RE: Submission to OBJECT AGAINST the redevelopment of the Convention centre, Exhibition and Entertainment precinct.

APPLICATION No. SSD 5752

SUBMISSION FOR APPLICATION No. SSD5752

ICC CONVENTION

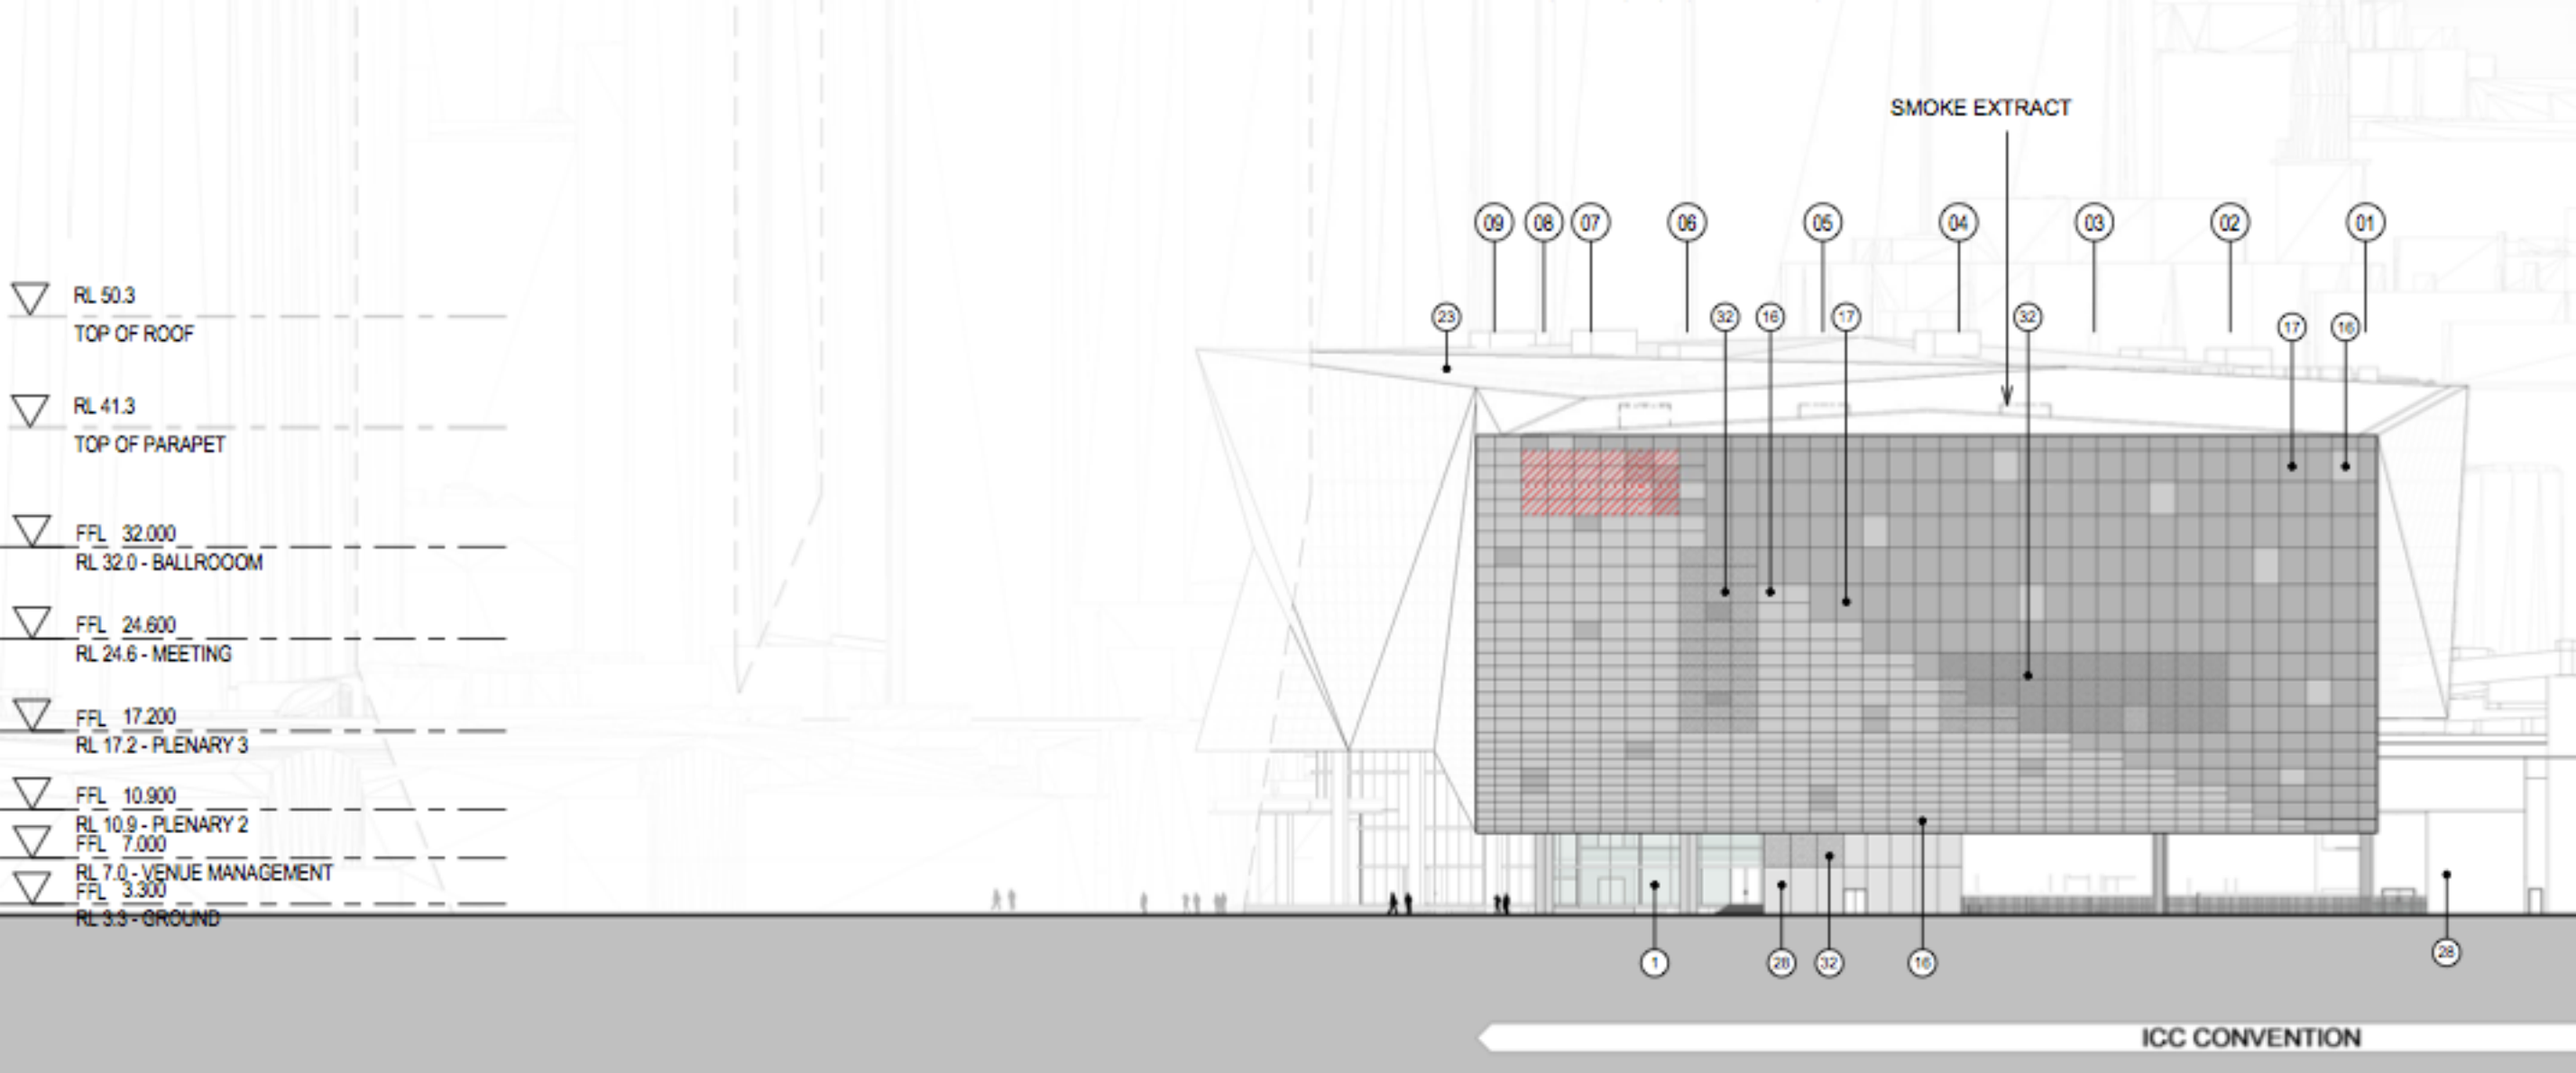
We firstly object to the height of the proposed new ICC convention centre which is nearly to the top of the Goldsbrough's current height.

In the DA plans the proposed height is RL 50.3 which will block the entire view to Darling Harbour and the city from the Goldsbrough's eastern facing apartments. There is supposed to be a concept of view sharing in the city but in this case the whole of the eastern view of the Goldsbrough will be blocked out by the new ICC convention centre.

In place of the current city skyline and Darling Harbour view there will be a flat blank metallic wall in its place, which is the rear of the proposed ICC convention building. The front of the ICC building looks to be nicely designed with glass and is broken up in angles, but the Goldsbrough will be facing an ugly flat back wall made of aluminum and mainly Grey.

DRAWING TITLE
 GA PLANS - LOBBY - LEVEL 0 (RL 3.3)

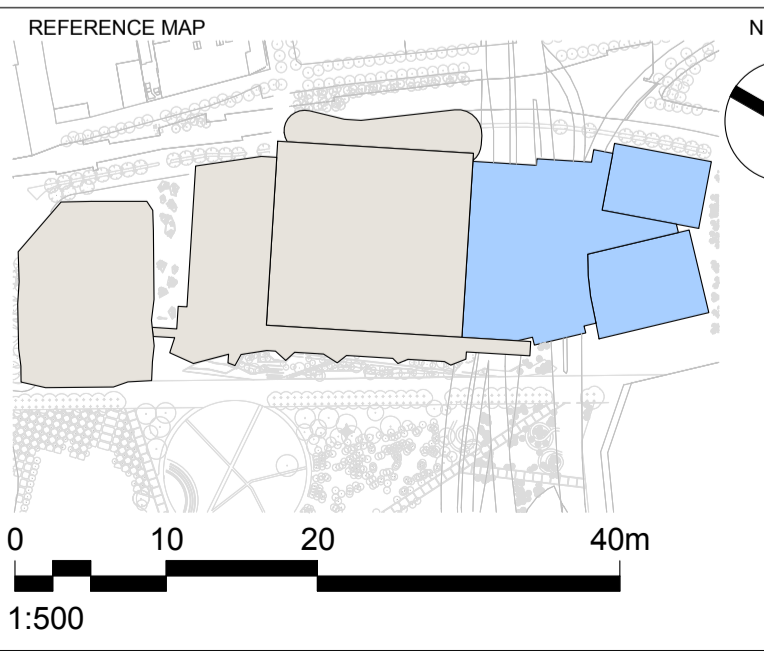
The proposed changes at Darling Harbour seem to take away an extremely important thoroughfare for the residents and guests of the Goldsbrough. From the plans it looks like the current overhead pedestrian walkway next to the Convention monorail station is being removed. Currently it is the easiest and safest walkway to enter the Darling Harbour precinct from the Western side.

From the Architectural drawings below it shows how the current walkway is removed in the proposed plan

This is the walkway being removed
